SSD 10349 Multi-Trades and Digital Technology Hub at TAFE Meadowbank

Attachment A – Comments on SSD 10349

PROPOSED SITE PLAN - CAMPUS NORTH

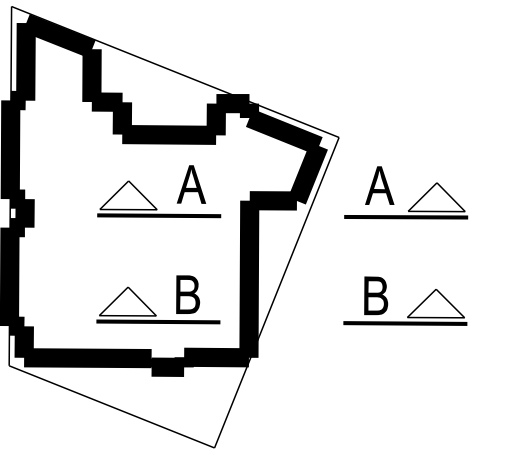
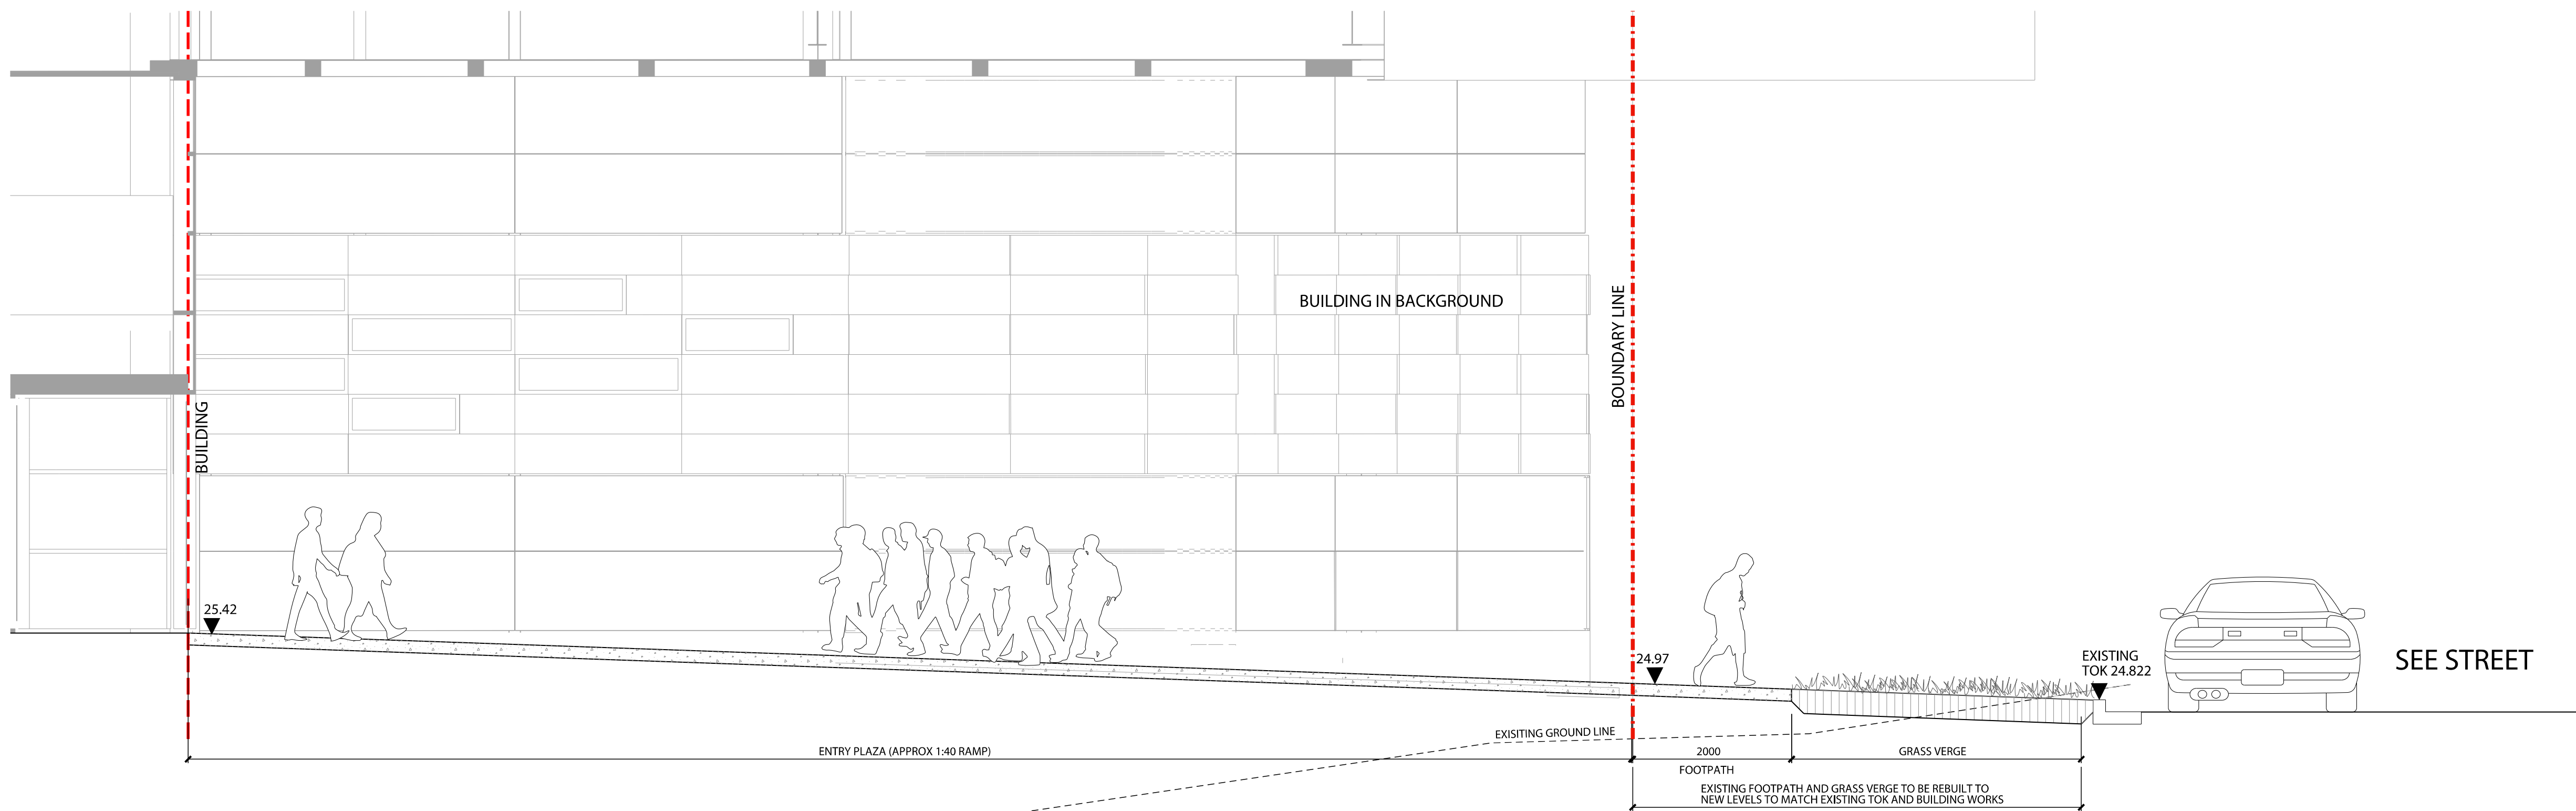
Vehicle access is proposed via See Street with a new east-west internal laneway to run along the northern boundary of the site between the Hub and the existing substation. Consideration should be made in relation to the Precinct School SSD that indicates the pedestrian access for the future high school and primary school will be on Rhodes Street and also in close proximity to the west access of the laneway.

Use of such laneway should be time restricted or for emergency purpose so as to not interfere with the school users i.e. safety issues.
